**Consultation Response from KC,
Conservation & Design**

2026/90231 George Hotel, St George's Square, Huddersfield, HD1 1JA

Discharge of details reserved by condition 15 (doors) on previous permission 2025/91148 for Listed Building Consent for refurbishment and redevelopment of the George Hotel (including partial demolition, partial reconstruction, extension, internal and external works and alterations) to provide a 108-bedroom hotel with bar, restaurant, gym, conference facilities and ancillary facilities (Listed Building and within a Conservation Area)

Date Responded: 2/3/26 & 21/4/26

Internal Door - A1D4-091 'Bedroom' - Location

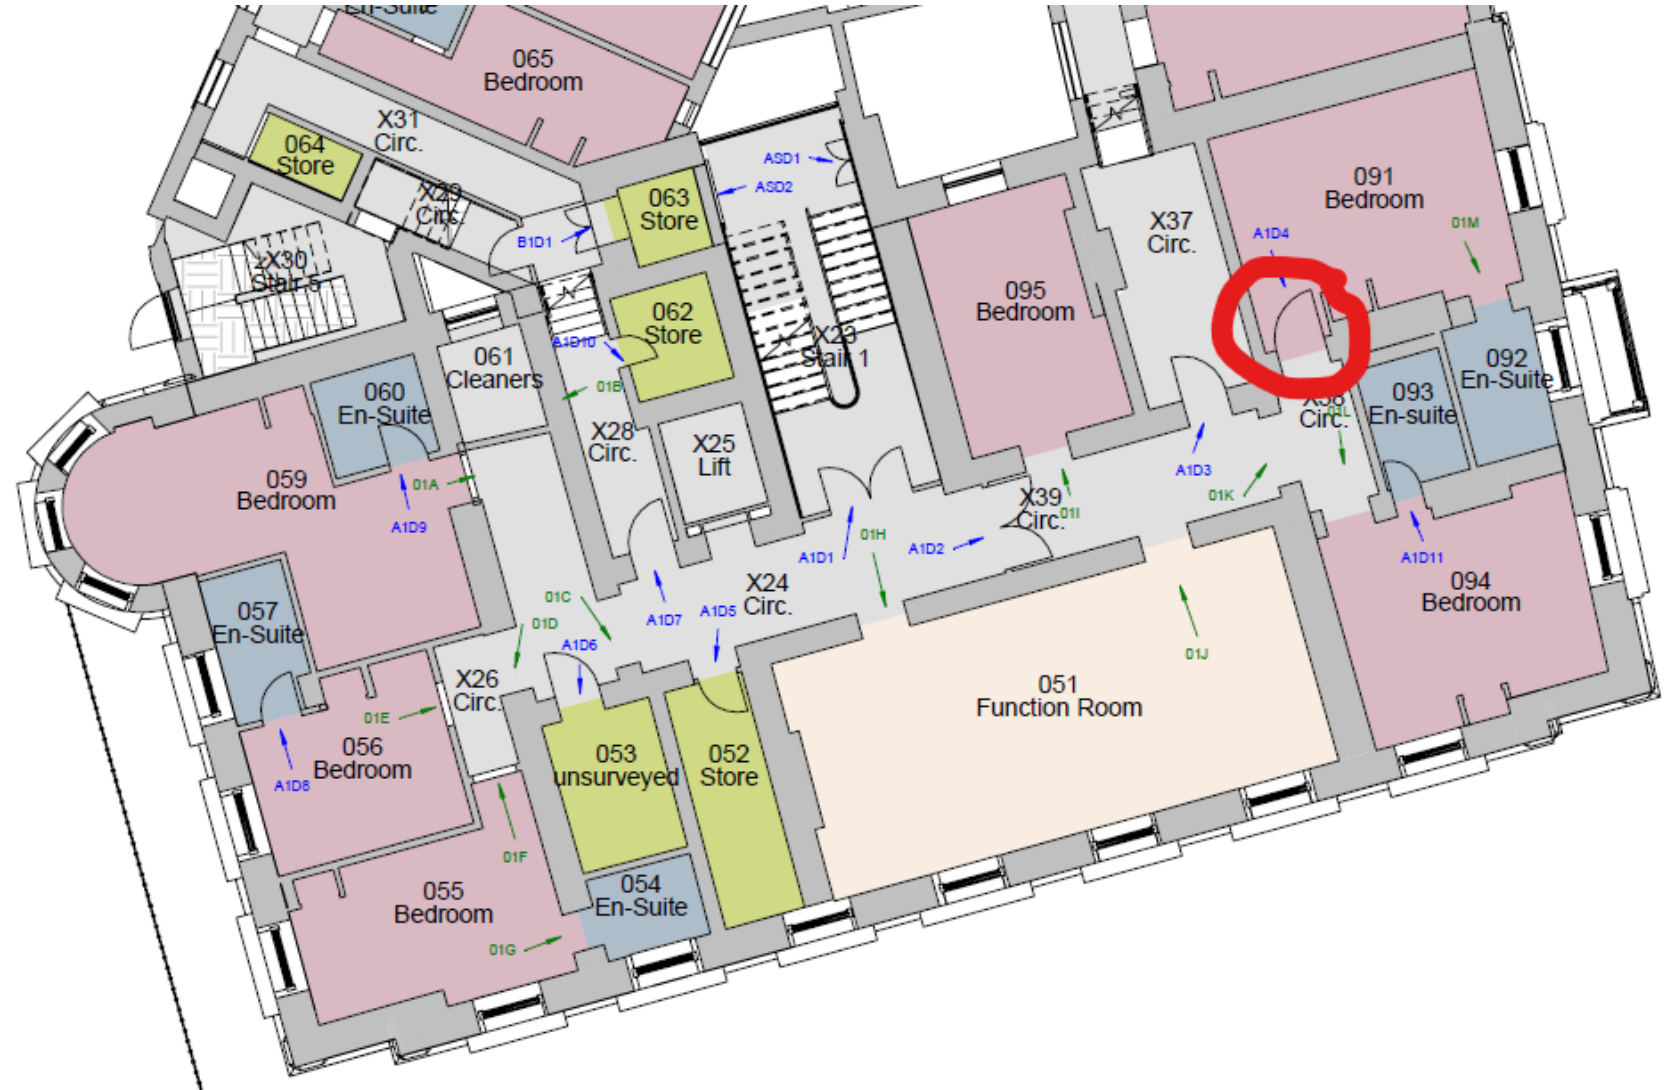
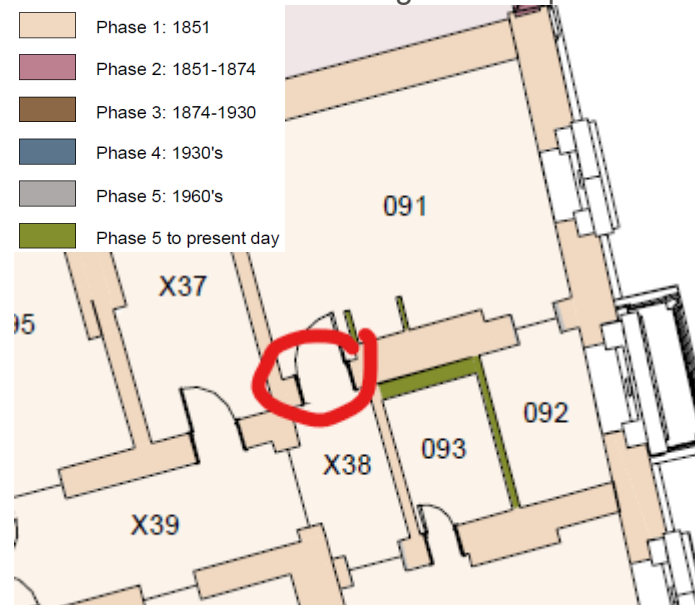
Bedroom 091 – has been incorrectly assessed previously.

Now assessed as 1960's 6x panel door – requires upgrade to 1 hour fire protection. Therefore, it is proposed to replace with a new heritage style door in solid hardwood to match the 1930's style 5 panel door.

The submitted details above are sufficient to Discharge the Condition's first bullet point.

Internal Door - A4D4-X73 'Circ.' - Location

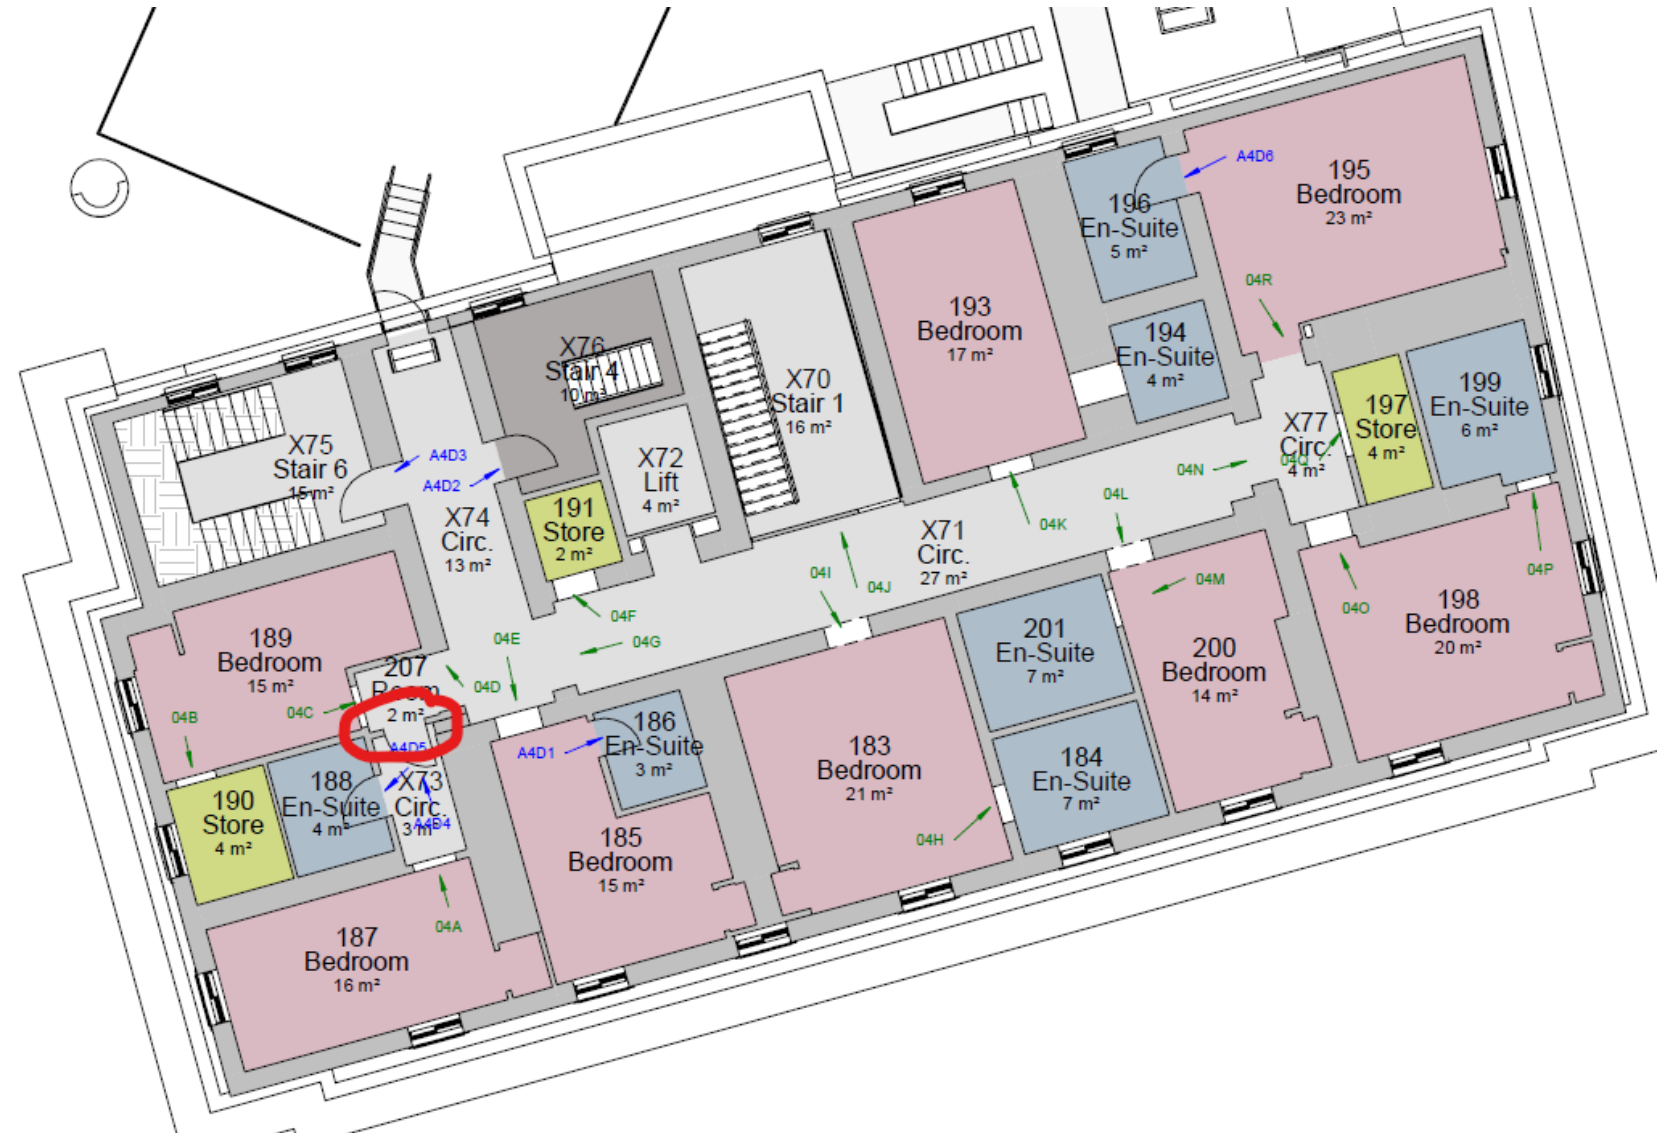
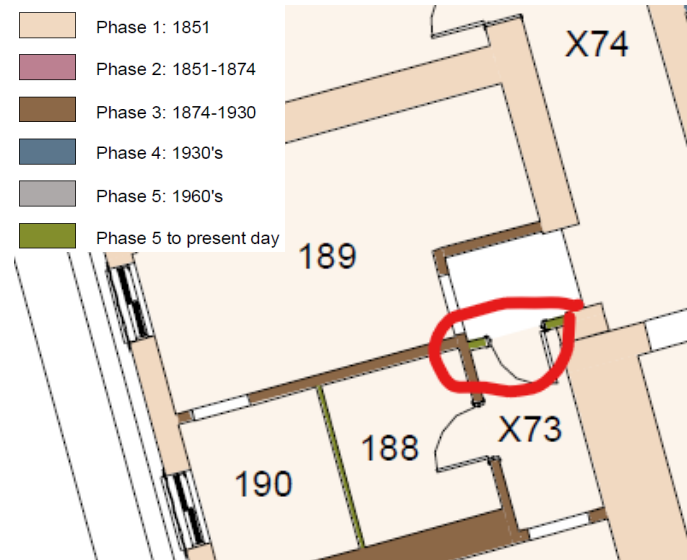
Bedroom X73 1930's 5 panel historic door. Propose to retain and relocate to the First Floor to be sited as a 'false door' (non-opening) with a new frame in corridor X39 adjacent to the entrance to the Signing Room. This would compliment the panelling and architraves in this location off the main corridor.

Internal Door - A4D6-196 'En-Suite'

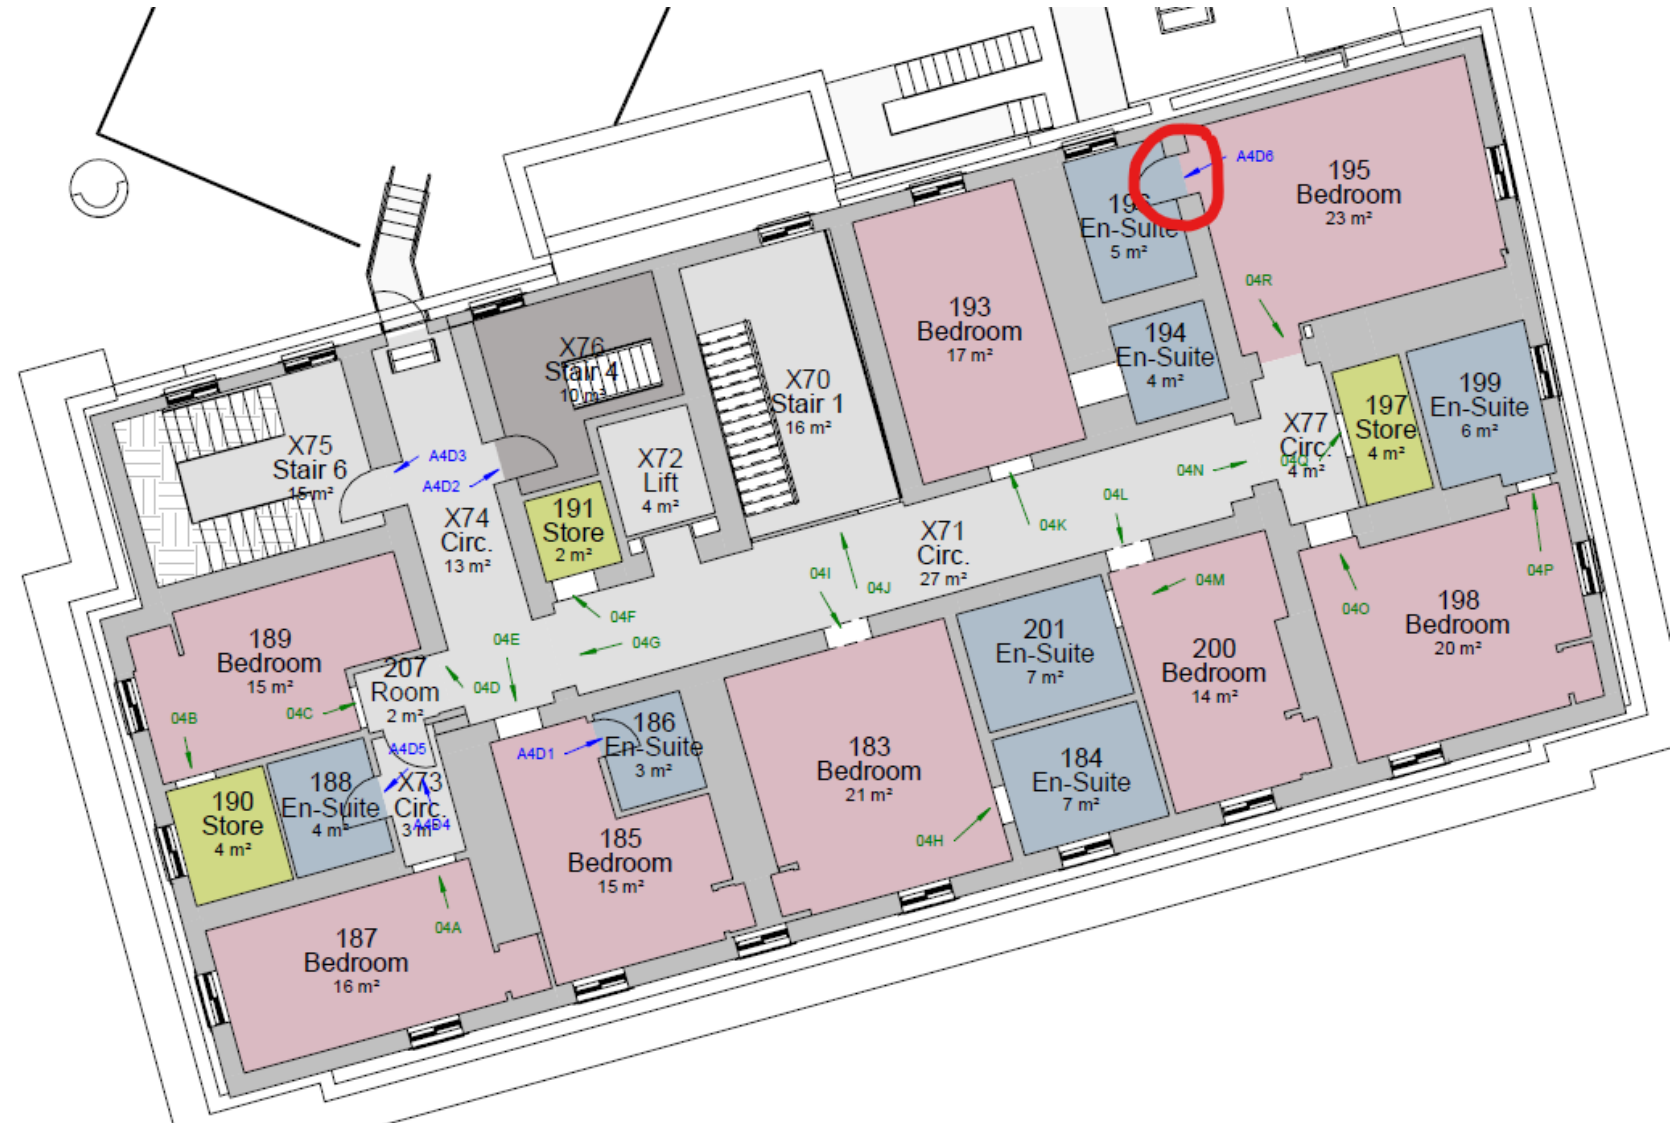
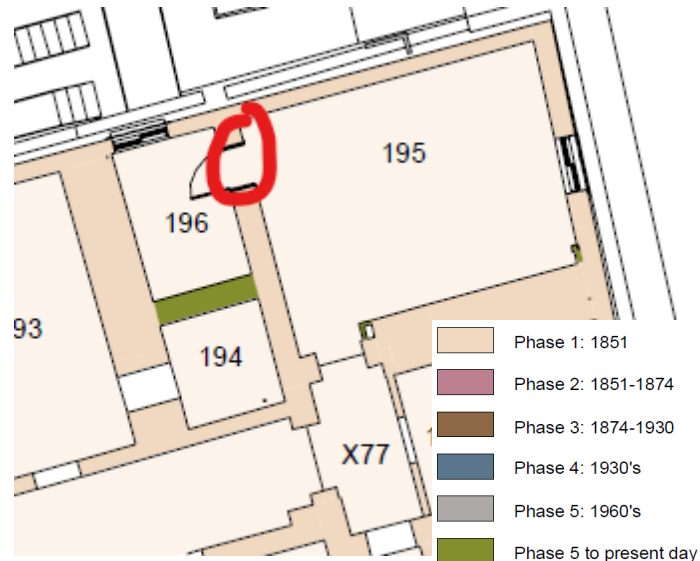
Ensuite 196 1930's 5 panel historic door. Propose to retain and relocate to Fourth Floor to be sited as a 'false door' (non-opening) in corridor X71 Circ opposite the main central staircase. This would compliment the architraves and overall setting opposite the main stairs off the main corridor.
